From: Giovanni Cirillo <giovanni@planninglab.com.au>
Sent: Friday, 5 February 2016 2:11 PM
To: Fiona Gibson; Anthony Witherdin
Cc: Giovanni Cirillo
Subject: The Esplanade, Ettalong
Attachments: DA Landscape Plan 050216.pdf; J15304 47-50 The Esplanade Ettalong Beach Town Centre _ DA _ C _ fullset _ 160204 2 low reso.pdf

The architect has revised the drawings arising from our last email exchange and I attach them to this email.

In summary, the changes address Council's submission directly, and the Department's identified issues, as follows by:

DA SUBMISSION		
Job no	Drawing no	Rev
J15304	DA 107	C
Drawn by	Checked by	Date
PY	ZC	NOV 2015

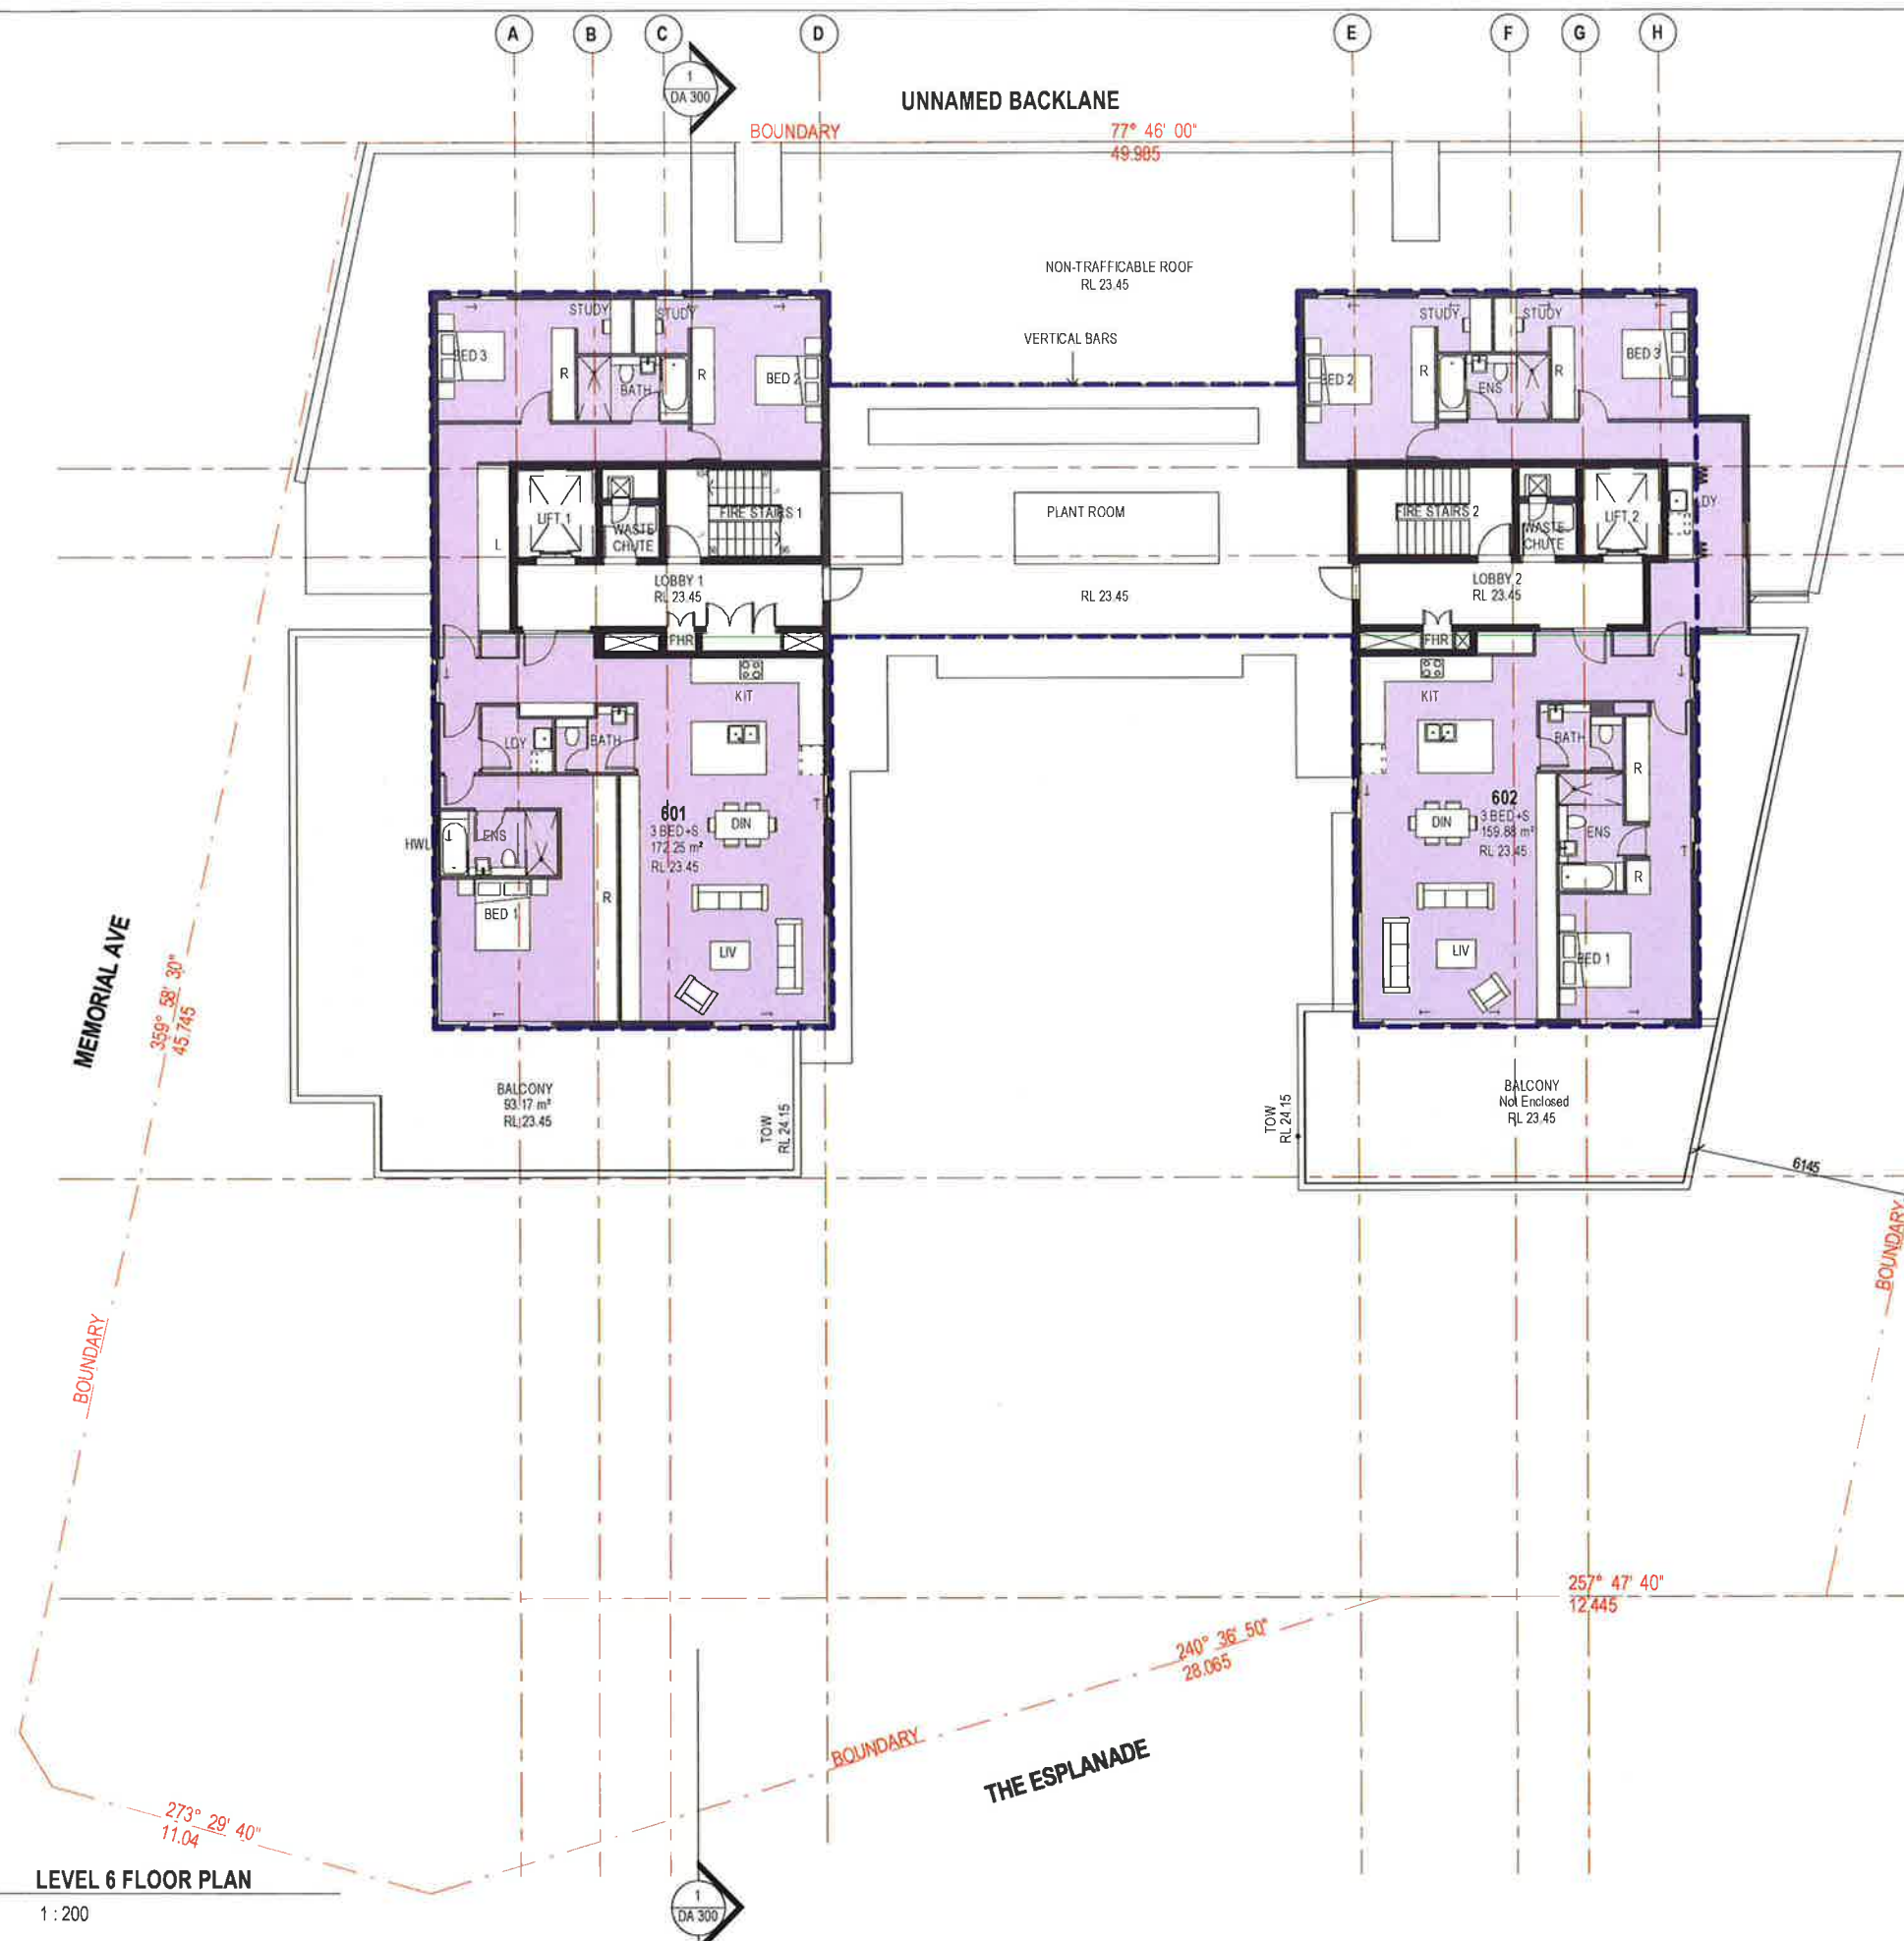
3. Increasing the setbacks from the boundary and reducing the size of the balconies on levels 4 and 5,
4. Tapering the edge profile and changing the colour and prominence of the balconies on levels 4 and 5 to preserve the predominant 3 storey scale of the development when viewed from the street;
